Ref: SSD-11233241

14 July 2021

Exhibition- Murrumbateman Primary School Project

PROPOSED SITE PLAN

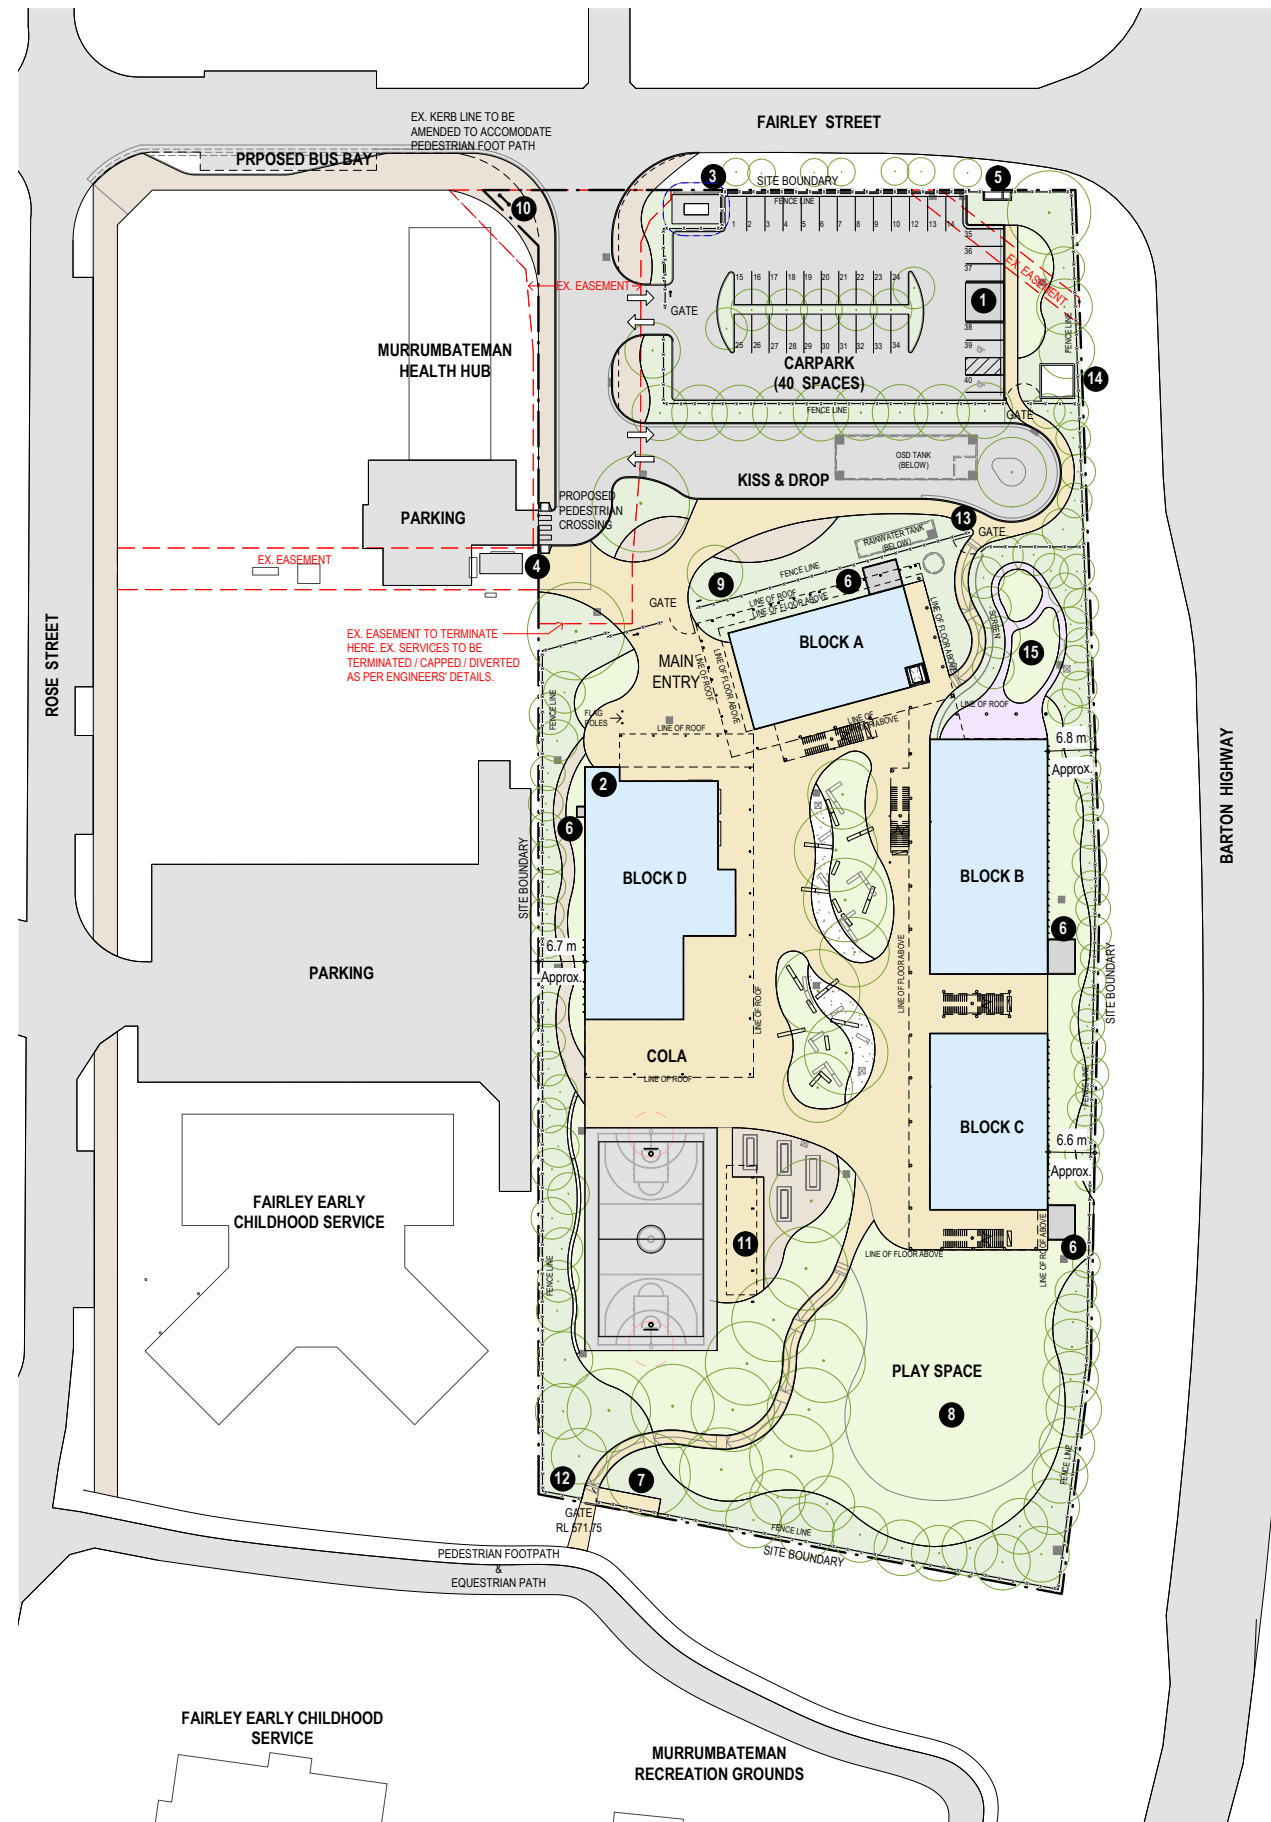
While locating an entry here provides connectivity into the older established part of the Murrumbateman community, the location of the bicycle parking/storage adjacent to the southern gate presents a security concern, as there will be no surveillance of this area- particularly during class times. It is suggested that this bicycle parking be relocated adjacent to Block C.

Figure 2: Site Survey Existing Easements (Clarke & Di Pauli Surveyors)

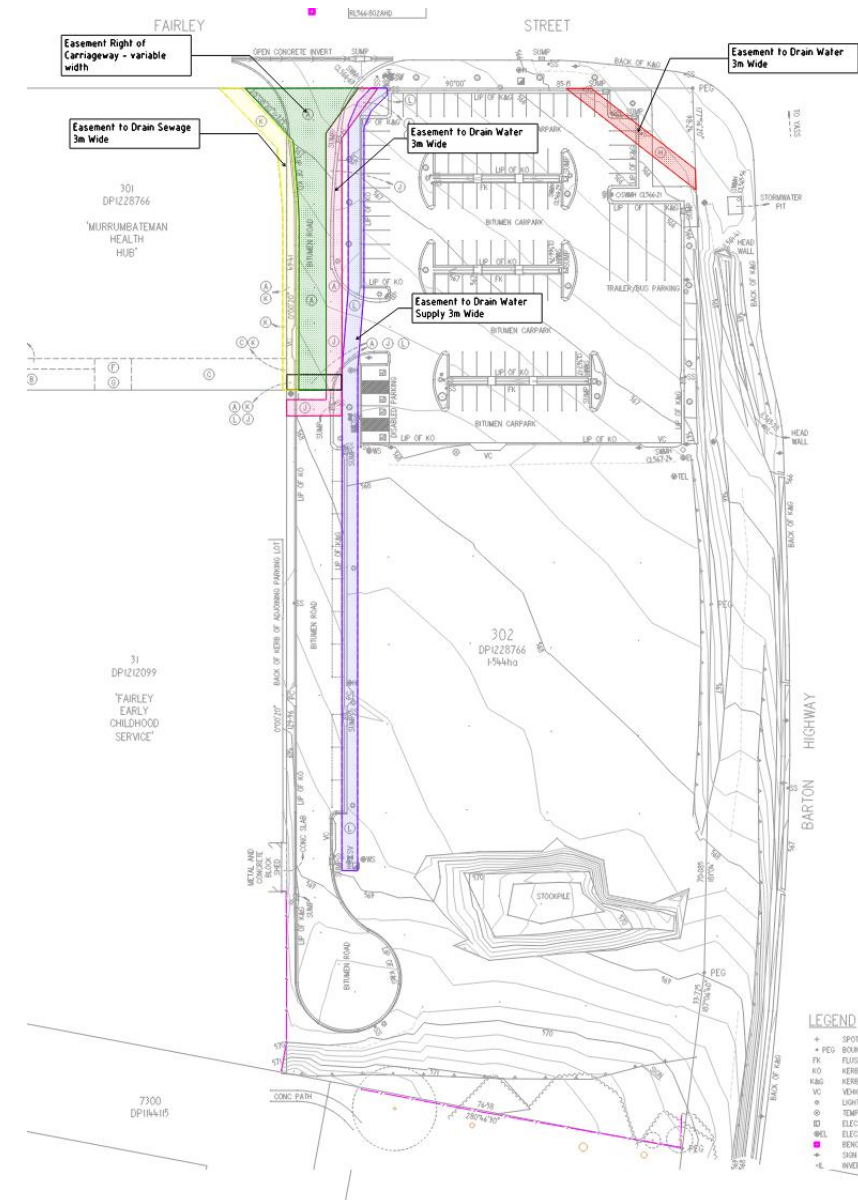
-Easement Extinguishment: The water main off Fairley Street was installed inside LOT 302 to service the then proposed commercial development and the Murrumbateman Health Hub. It is a Council water main inside a private lot, thus the easement.

With the proposed development of the school, if the section of the water main beyond the Murrumbateman Health Hub is not required then the easement could be extinguished. However, this needs to be confirmed with Council's Water and Sewer Manager as well as the hydraulic designer who

has made assumptions based on the water main existing layout. There is also stormwater main running to the side of the water main which services the Fairley Child Care/Commercial Area as well.
